Householder Proforma

Application Ref: 2022/0266

Address: 66 Clarel Street, Penistone, S36 6AU

Proposed: The proposal is to replace the conservatory with a brick built rear extension integrating with the existing lean to rear extension. The proposal will be built on the same footprint as the existing conservatory projecting 4.78m to the rear, 2.75m in width, 2.33m to the eaves and 3.75m total height. The door openings and window positions will mirror that of the conservatory. The gable end will face into the garden and will have long window up to the roof to provide additional internal daylight. Velux windows will be located on the roof slope facing the garden and some velux roof lights will be installed within the existing lean to. The proposed materials will match those of the host property in brick and tile.

**PROPOSED
REAR ELEVATION**
SCALE 1:100

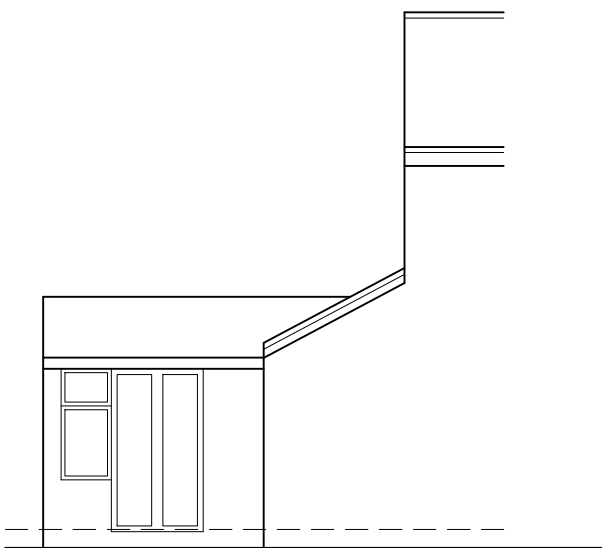
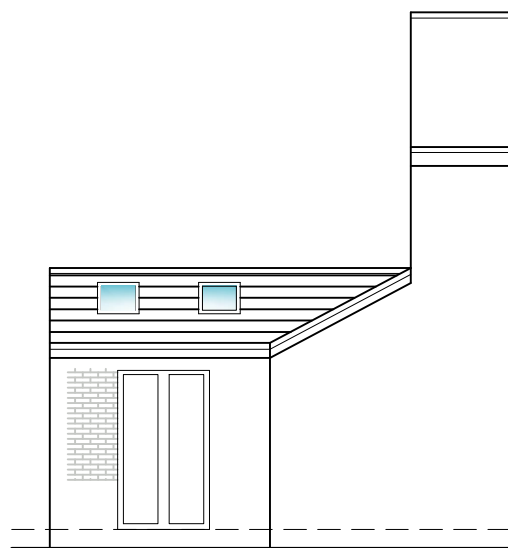
Yes
Single Storey	
1. terraced property and less than 3.5m (projection to rear)?	N/A
2. semi-detached and less than 4m?	No, the property is semi-detached with a projection of 4.78m. This is against the policy principles set out within the SPD, however, the proposal is to replace the existing conservatory within the same footprint, therefore the impact to the adjoining neighbour will be similar to that already tolerated. Furthermore, prior notification can be sought for a larger extension up to 6m, if the relevant guidelines are met. The neighbours have not objected to the proposal, and as the impact to the adjoining neighbour will be similar to that already experienced in this instance the proposed projection is acceptable.

3. if more than 3m are the eaves more than 2.5m in height?	No, 2.33m in height which is under 2.5m
Two Storey	
4. terraced property and less than 2.5m (projection to the rear)?

5. semi-detached and less than 3.5m?	
All	
6. materials to match	Yes brick and tile to match
7. roof design compliments / ties in well	Yes, matching pitched, ties in well with the existing rear extension

8. habitable room windows on the side elevation?	Yes, patio doors will face towards the neighbouring property identical to the existing. The boundary treatment provides adequate privacy for the neighbouring residents in line with planning policy
9. distance to rear boundary (shared with another residential property) 10m or more?	Rear boundary shared with school, with adequate privacy presently experienced by way of fencing, tree and vegetation coverage.
